WEST SUSSEX COUNTY COUNCIL CONSULTATION

TO:	Arun District Council - FAO: Simon Davis
FROM:	WSSC - Highways Authority
DATE:	22 September 2020
LOCATION:	26 Burnham Avenue, Bognor Regis, PO21 2JU
SUBJECT:	BR/190/20/OUT Outline application with all matters reserved for 10 No. new dwellings consisting of 1 No. 1 bed property, 8 No. 2 bed properties & 1 No. 4 bed property with associated services, landscaping, car parking & amenity (resubmission following BR/49/19/OUT).
RECOMMENDATION:	Advice

SITE PLAN (PROPOSED) 1:200

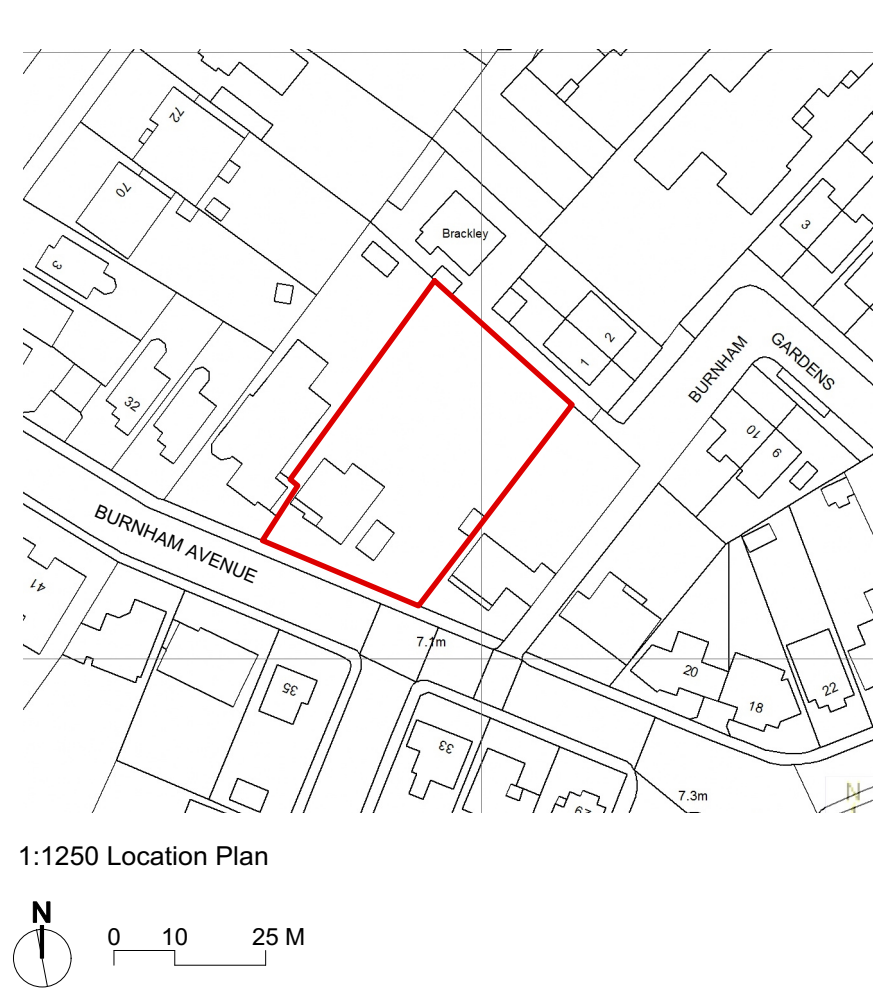
There are no parking restrictions on Burnham Avenue and on-street parking takes place both sides of the carriageway. The nearby junction with Victoria Drive to the west is protected by double yellow line junction protection markings. The existing dropped kerb would be extended to provide access to a rear parking area and frontage parking. The access route in the site is not wide enough for 2 x cars to pass in opposing directions. Considering the anticipated traffic levels and low speeds the LHA could not raise a highway safety concern to these arrangements. Nevertheless, the applicant may wish to consider widening the access route to improve the arrangements from an amenity point of view. At reserved matters stage it would be useful for the applicant to demonstrate through swept path tracking plans that cars can turn on site.

No objection is raised to the principle of the access however the applicant should be aware that a license to construct the vehicular cross over would need to be obtained from the Arun Area Engineer. It should be noted that a licence at this location may not be granted due to the total crossover width exceeding 6.4m; due to the existing parking pressures and the loss of on-street parking provision for neighbouring residents. It is recommended that the LPA consider the amenity impact of the proposed development should permission be granted. The LHA acknowledge the Area Office's guidelines regards access width. Nevertheless, from a highway safety point of view the LHA could not substantiate grounds to resist the proposal. The potential loss of an on-street parking space would not cause a highway safety reason for refusal.

Arun Supplementary Planning Guidance Document (SPD) advises that in Zone 4 1 & 2-bedroom dwellings require 1 x space each and 4-bedroom dwellings require 2 x space each. On this basis the development of 1 x 1-bedroom, 8 x 2-bedroom and 1 x 4-bedroom would require 11 x spaces. The plans indicate total 13 x spaces across the site plus a single garage (0.5 space). Two of the spaces will be unallocated/visitor parking as required by the SPD (20% total units). The LHA are satisfied with the indicated level of parking provision though the applicant may wish to revise the layout to allow for two cars to pass within the site and access, this is considered more of an amenity concern.
